COPI MINERAL SADS PROJECT – SSD-41294067 - EXH 70795958

I refer to your recent information in regard to the Environmental Impact Statement (EIS) for the proposed Mineral Sands Mine located to the north of Lake Victoria.

Figure 6.2.2
PREDICTED GROUNDWATER
DRAWDOWN - END YEARS 10 AND 15

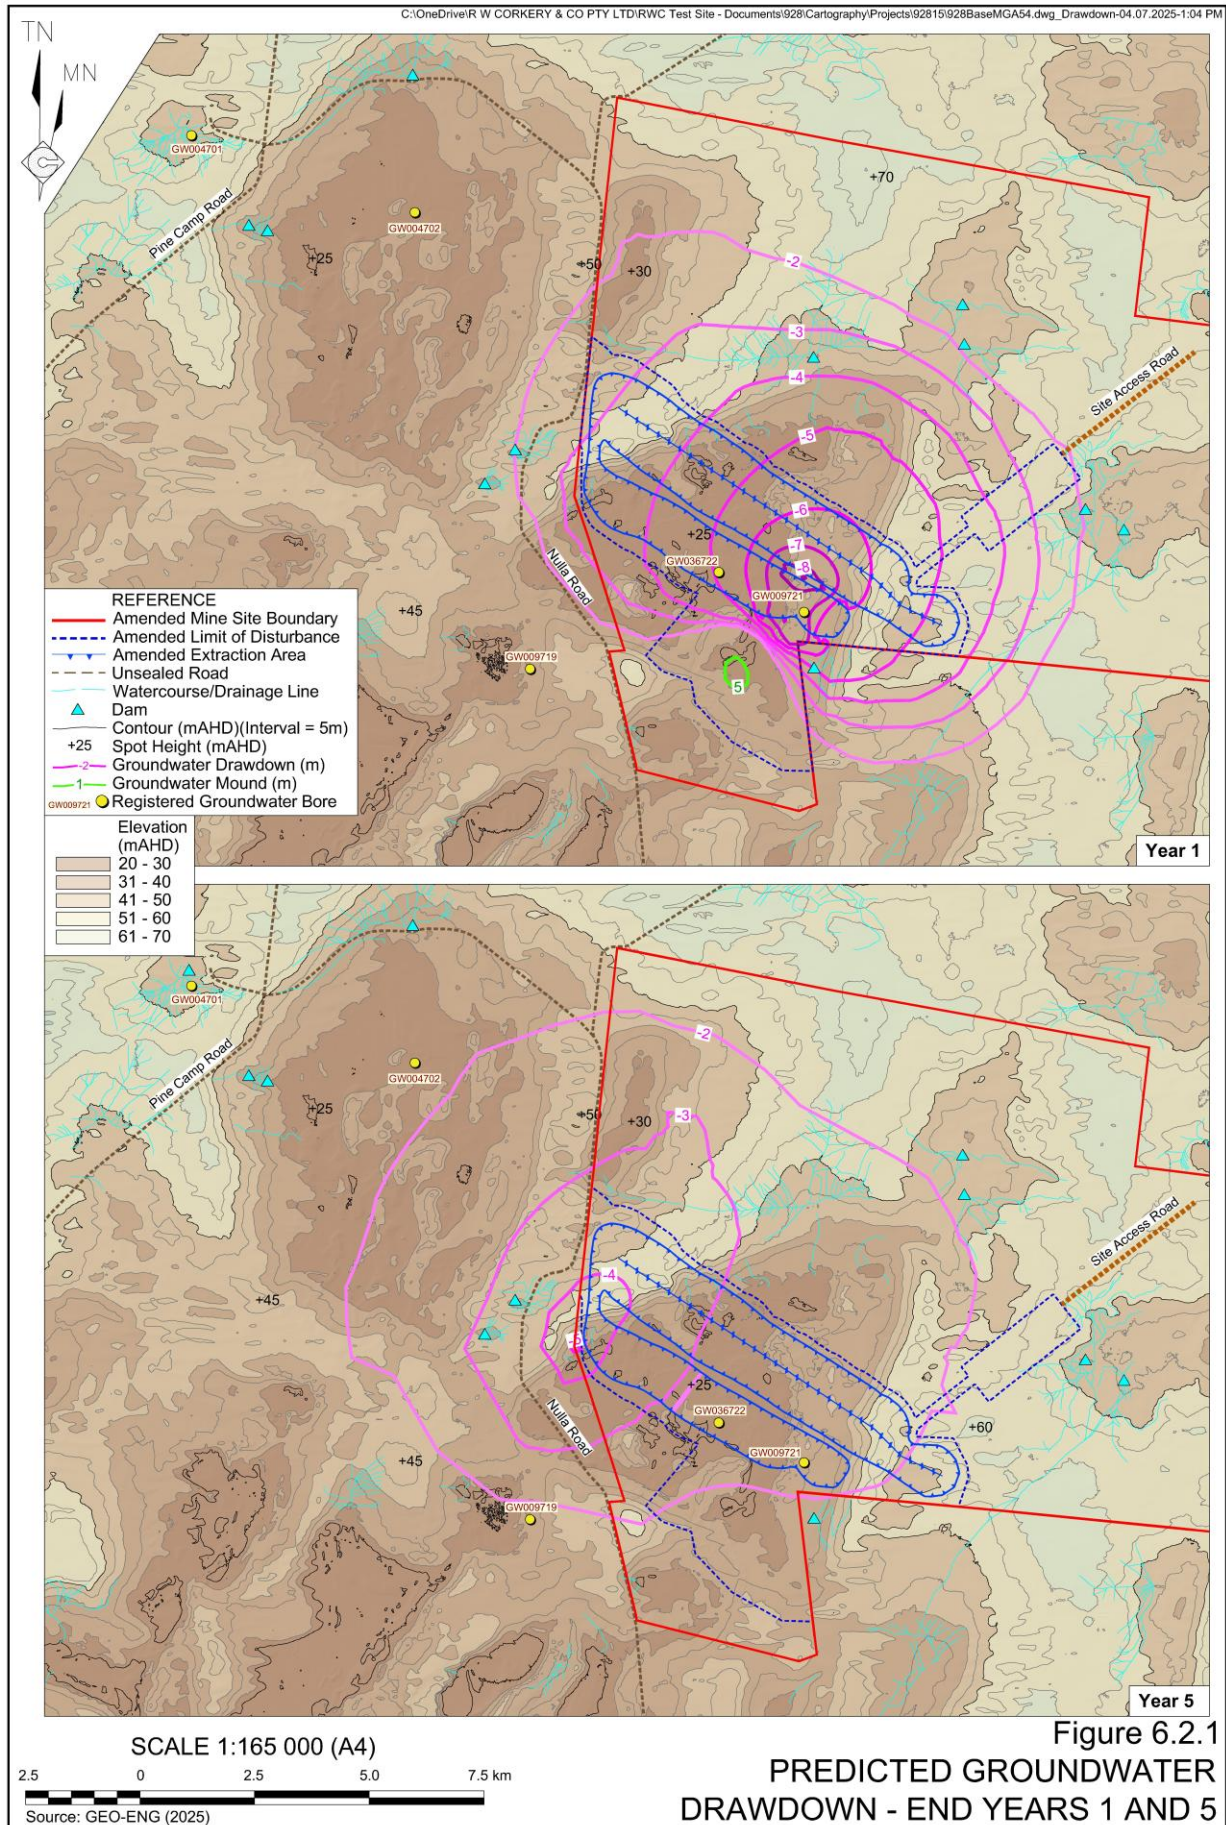
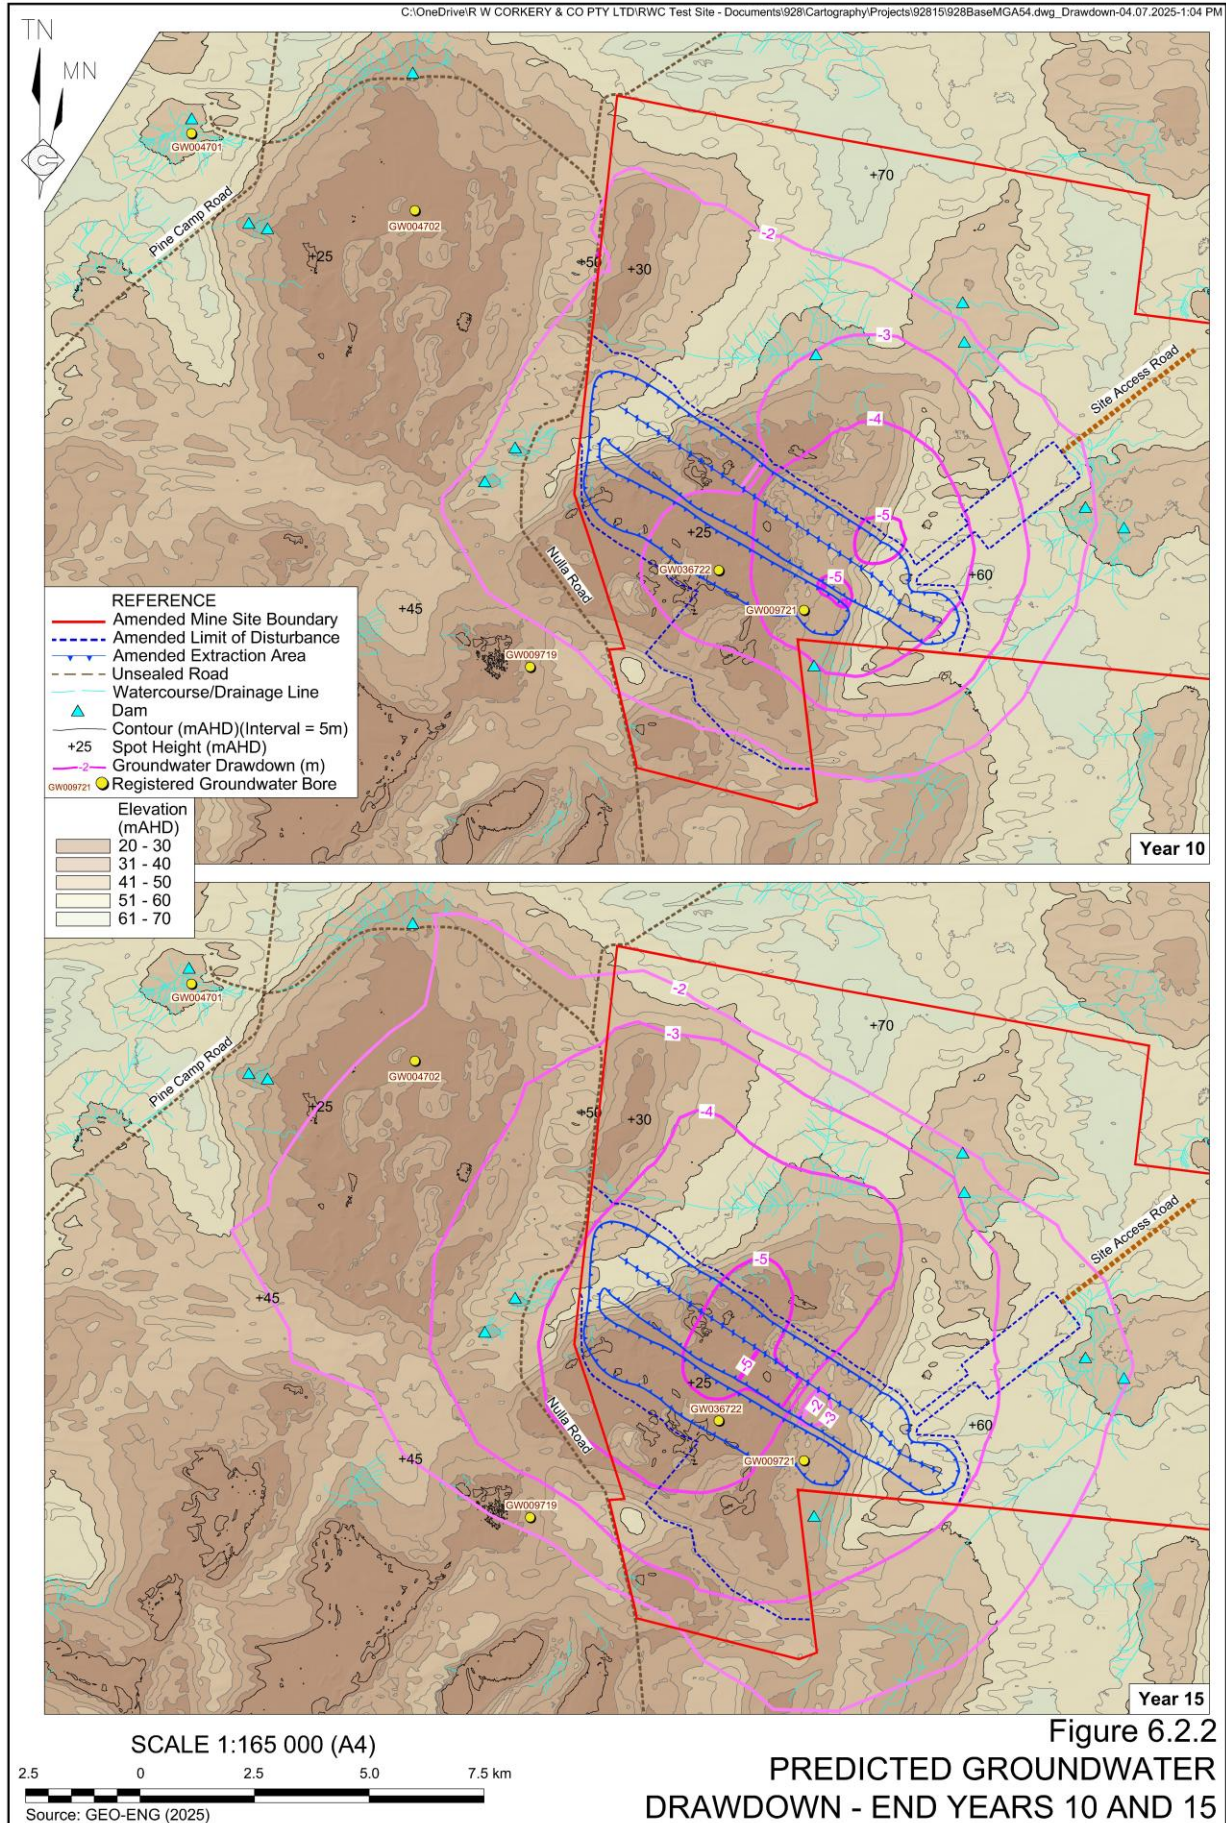
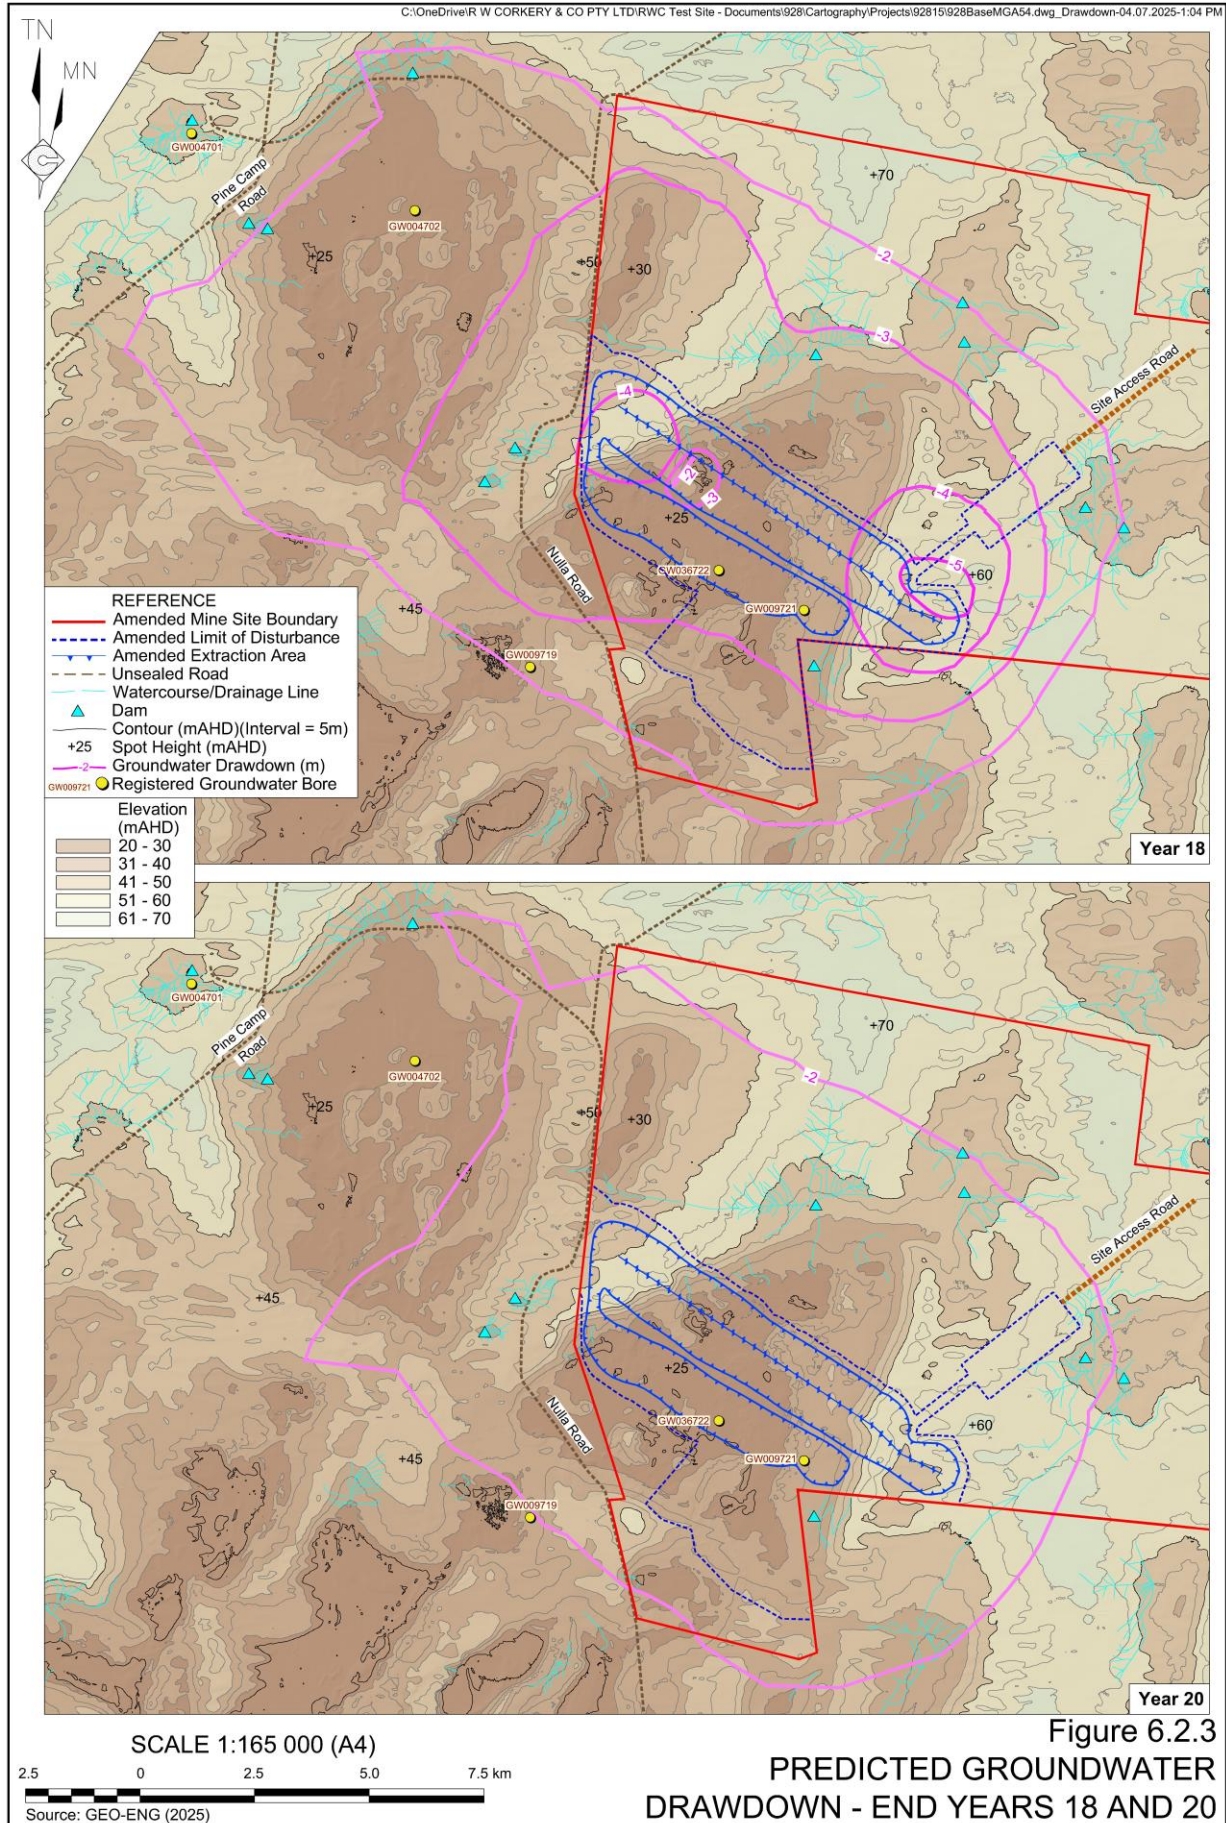
The proposed mining technique and water extraction provided in the EIS, indicates the potential for mixing of the shallow and deep aquifer in this location. The studies provided in the EIS documentation indicate that any mixing of the aquifers would be low likelihood and of limited risk to the local and regional aquifers and environment.

The proposed short- and long-term monitoring of groundwater bores and network, does not seem sufficient to provide advance notice of any issues that may be caused by the proposal. It is requested that additional monitoring on the local and regional networks be undertaken and publicly reported and provided to local neighbours for information and consideration. This monitoring should be enduring as any impacts will potentially last into the decades to remediate.
